**WEST SUSSEX COUNTY COUNCIL
STRATEGIC PLANNING CONSULTATION**

SUBJECT: FP/179/11-Demolition of existing dwelling & outbuildings and erection of 6 x apartments with associated parking & landscape (re-submission followinf FP/182/10)

30, Limmer Lane, Bognor Regis, West Sussex, PO22 7ET

#	LO	30/01/2012	1st Issue
Rev	By	Date	Rev
Client John Owen			
Job 30 Limmer Lane Felpham, Bognor Regis, West Sussex.			
Drawing Proposed Apartments Highway works and Visibility			
Date	January 2012	Scale	1:100@A1 1:200@A3
Drawn By L.O.		Dwg. No. 030510/SL-40

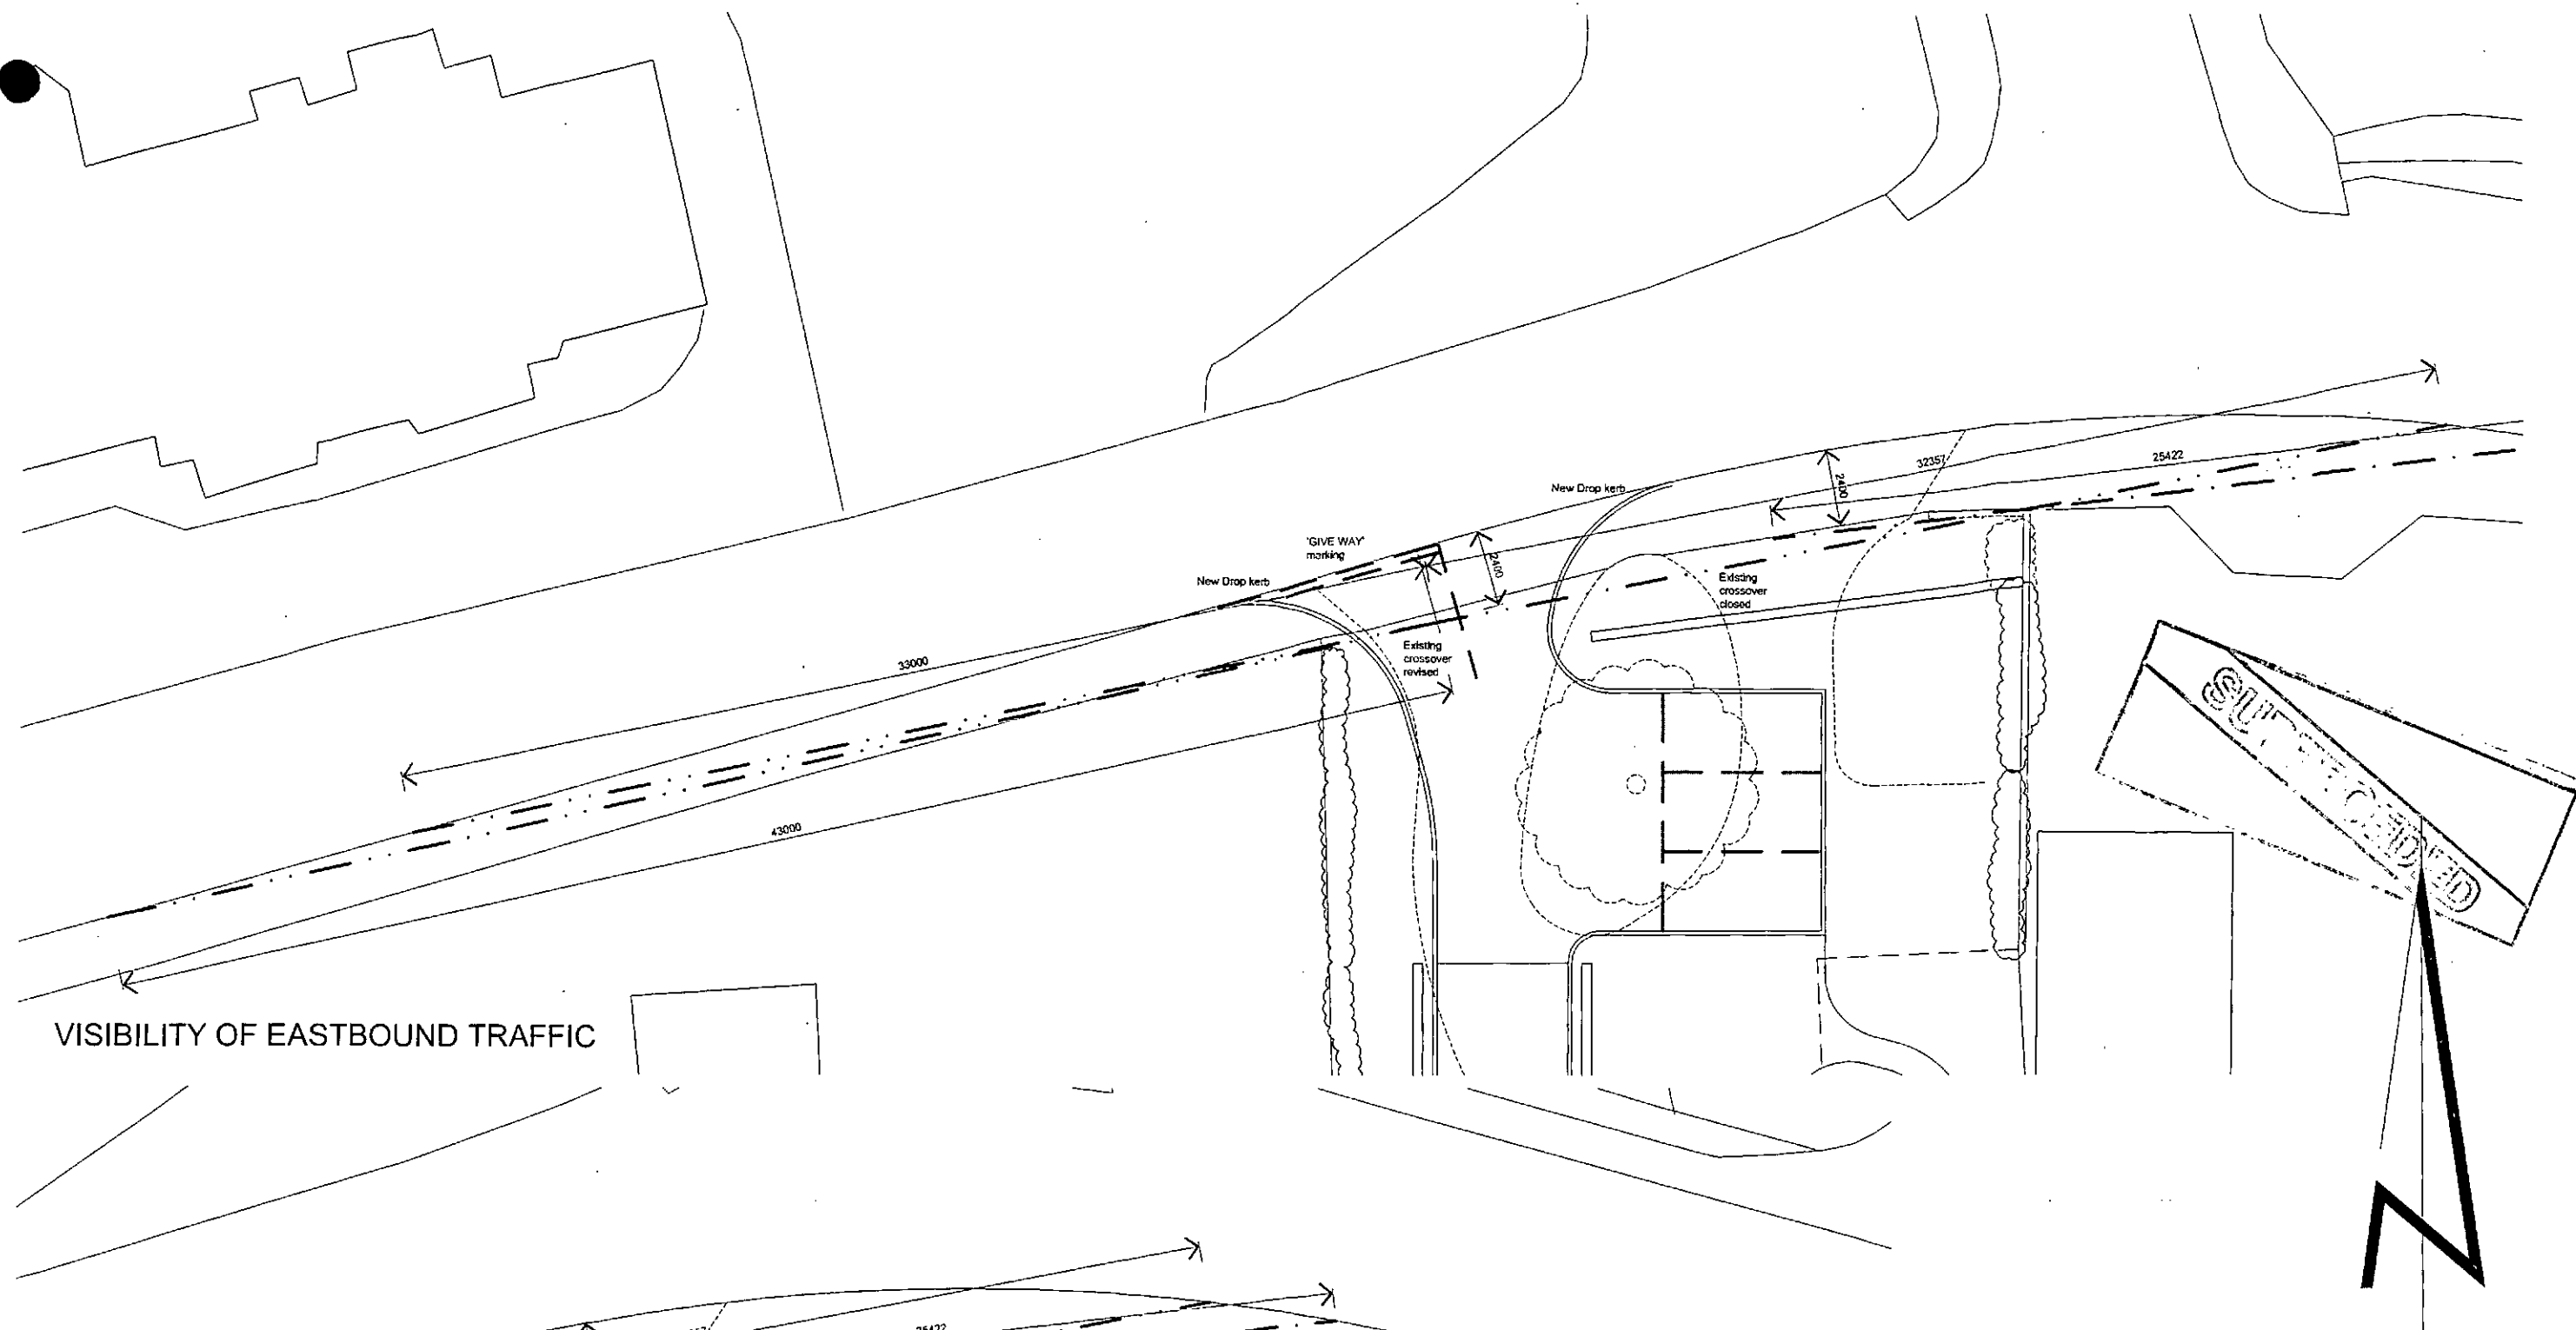
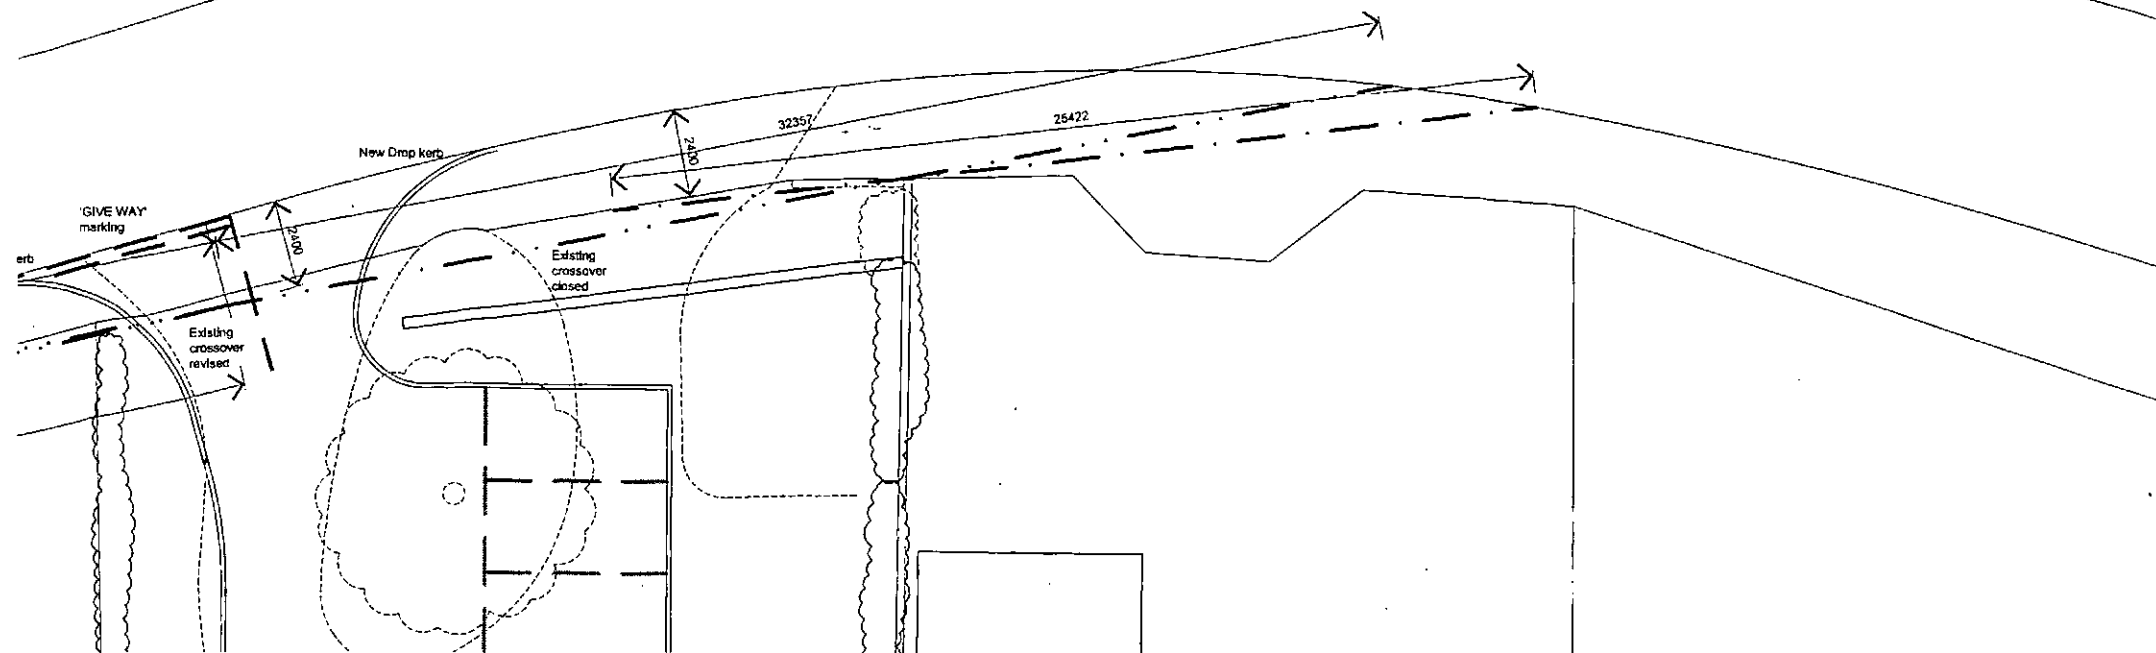
This latest scheme is a reduction in unit numbers over the previous proposal; however, there is still no further information with regard to visibility splays. There is a bend in the road and a brick pillar to the east of the site which restricts visibility to and from the site entrance and every effort should be made to enhance visibility at the site entrance to compensate for these features. The site entrance should preferably allow two vehicles to pass each other safely to avoid the need for vehicles to wait on Limmer Lane.

We would require the applicant to undertake a speed survey in order to ascertain the required level of visibility which will be required. We would apply Manual for Streets standards for visibility splays in this location.
